Your Ref: OWPC15631
Our Ref: FP/180/17/PL 20-07-2017
Please ask for:
Mr S Davis

Demolition of 1 No. dwelling & erection of 2 No. dwellings.
84 Flansham Lane Felpham

Planning Application FP180/17/PL

Appendix 4 Tree Constraints Plan

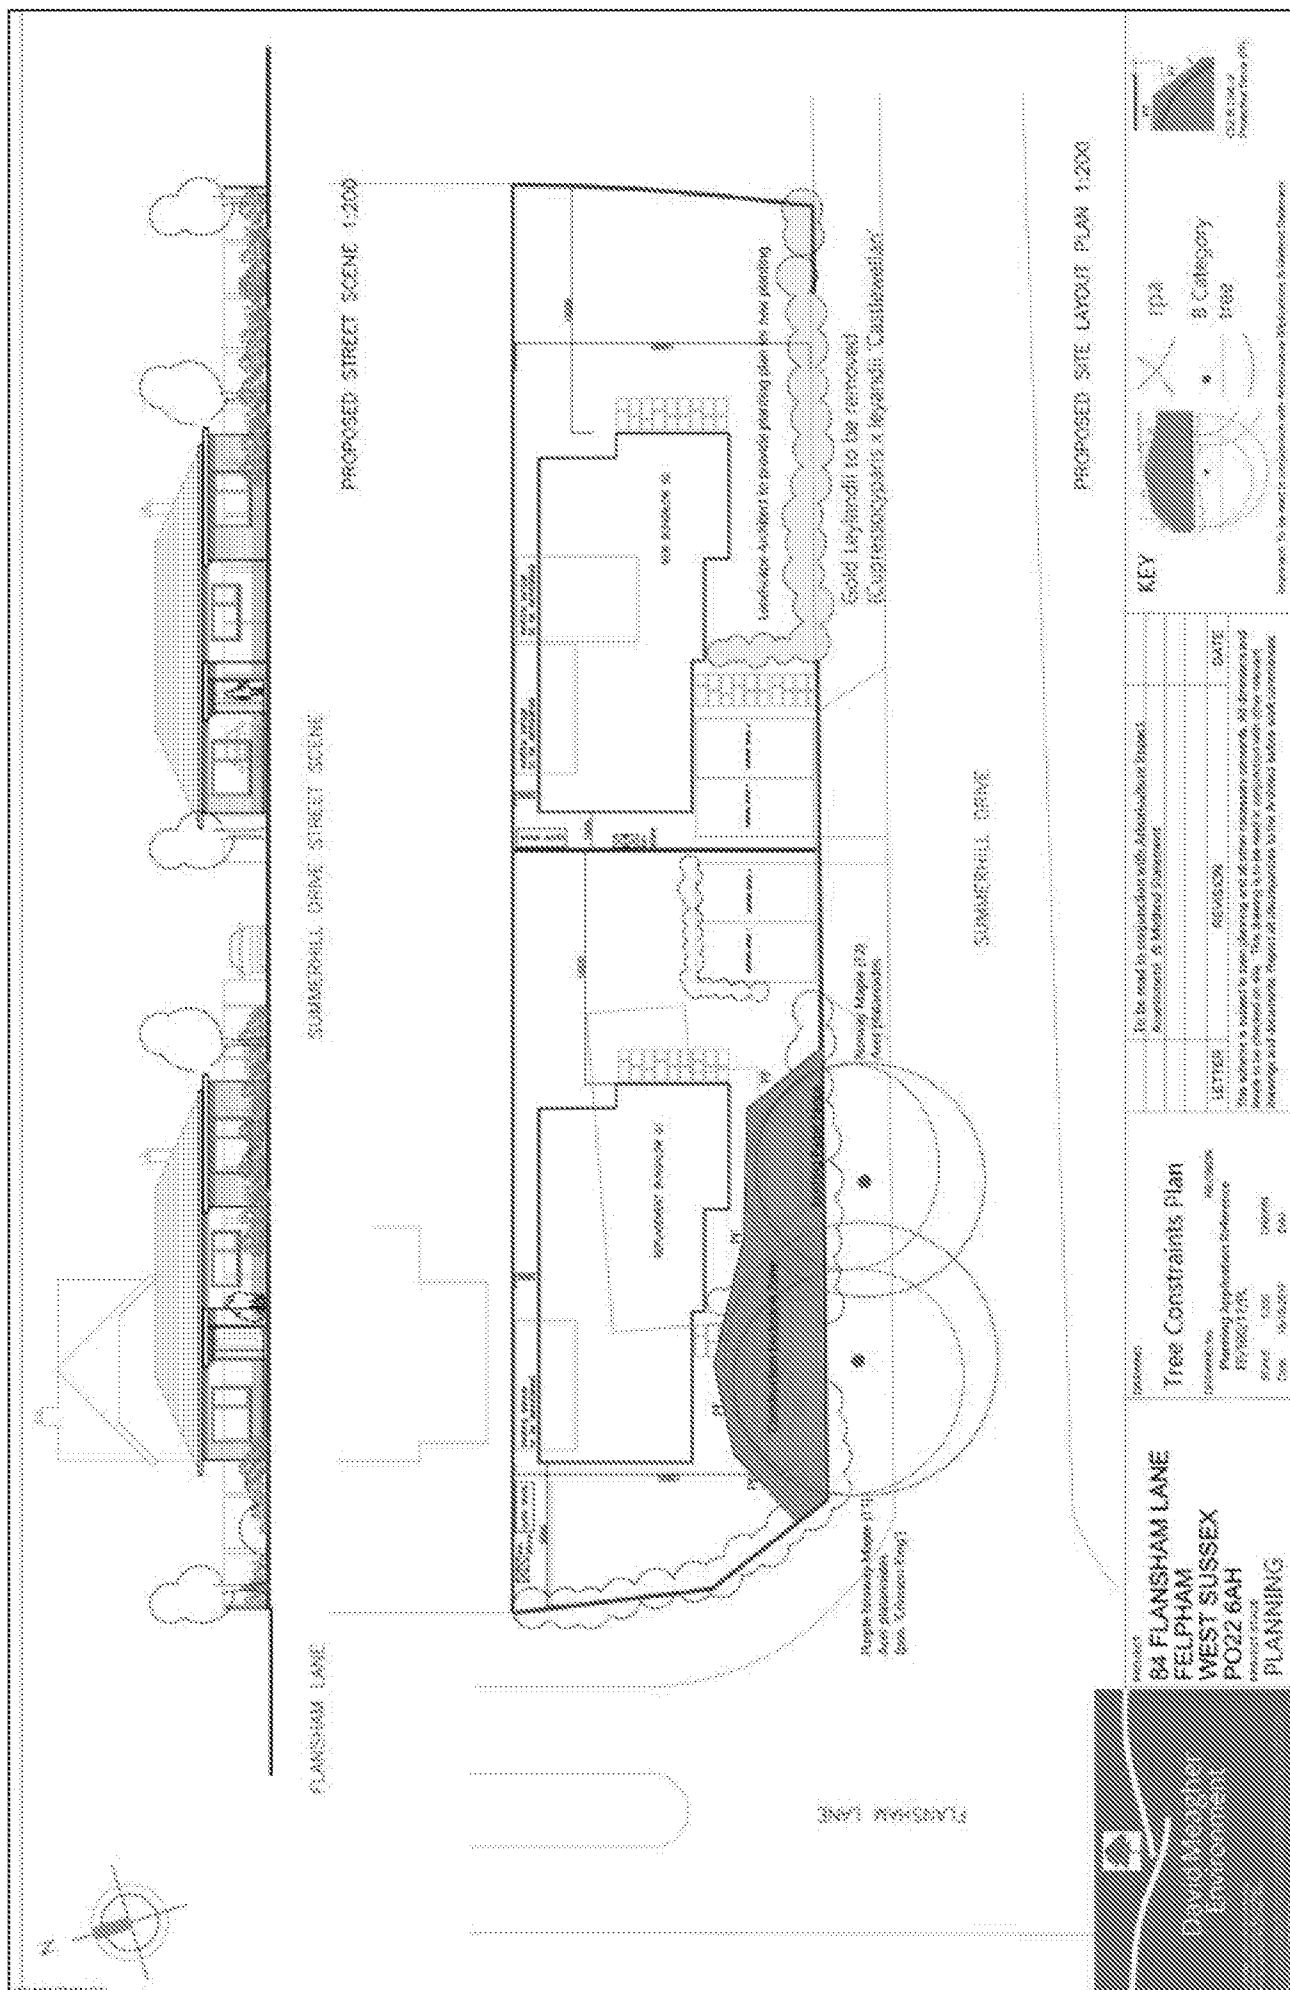
Firstly no detail has been shown on the plans of the two mature trees and the conifer hedge that are growing in the verge in Summerhill Drive. This is necessary to assess how the grass verge, trees and conifer hedge will be treated and also for that matter the type of boundary to be provided between the bungalows and the grass verge. This is very important as the Residents Association is keen to work with the developer on improving the visual aspect of the access into the estate as, I assume, these two properties will be included with an address in Summerhill Drive.

On the previous application for the site the Residents Association were keen to protect the conifer hedge and a condition was placed on that application to preserve the hedge. Given that two bungalows are now proposed on the development site the Residents Association are happy for the conifer hedge to be removed and the frontage of the bungalows to be visible from Summerhill Drive which will incorporate the properties better into the street scene. In these circumstances it is important that the boundary provided is a dwarf wall similar to that provided for other adjacent properties and elsewhere on the Estate. It is also important that the verge is suitably landscaped with trees/shrubs to aesthetically enhance the development.
